Our Ref: 20/00924/HOU
Your Ref: 29 nutbourne road

LOCATION: 29 Nutbourne Road, Portsmouth, PO6 1NP, ,

PROPOSAL: Construction of single storey rear extension **(20/00924/HOU)**

Proposed Rear Elevation

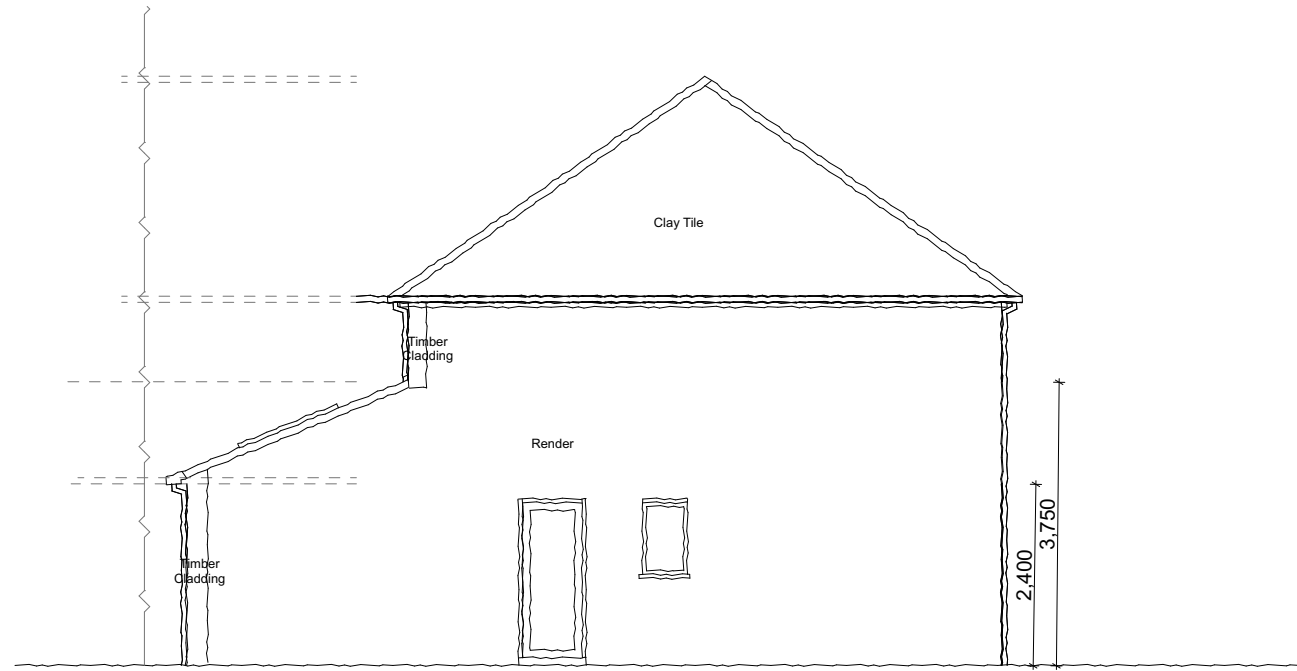
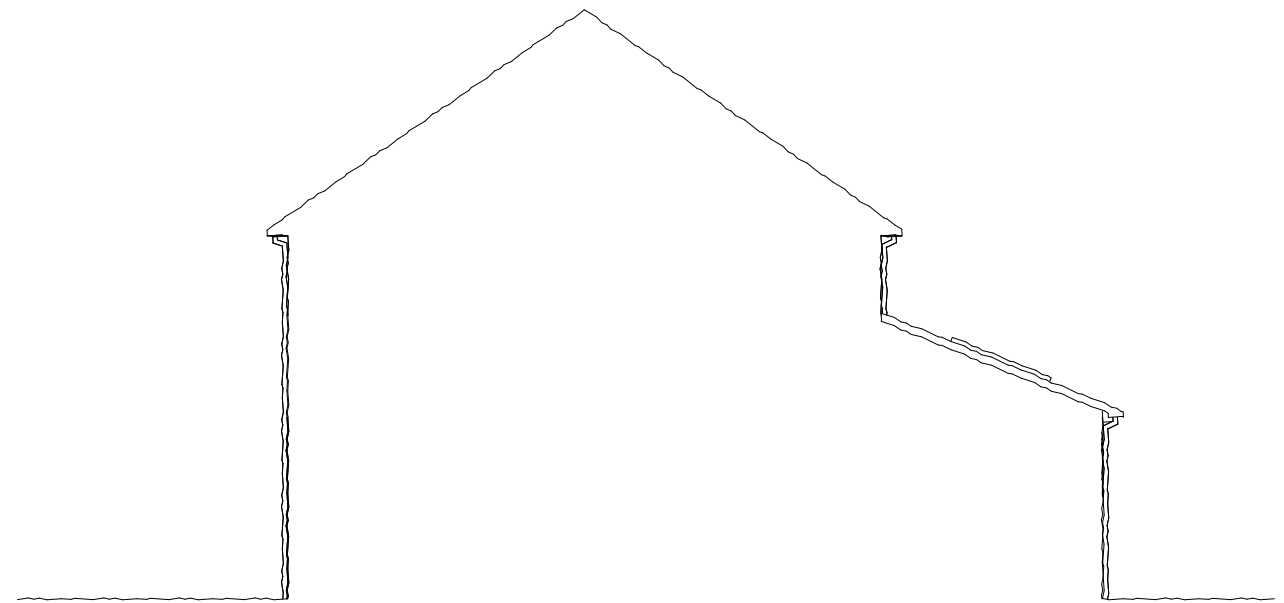
- 1) It is a requirement that all drawings are accompanied by scale bars for every sized used. Please resubmit your drawings with the appropriate scale bar(s) included.
- 2) Both side elevations required for existing and proposed plans
- 3) Room labels on floor plans required
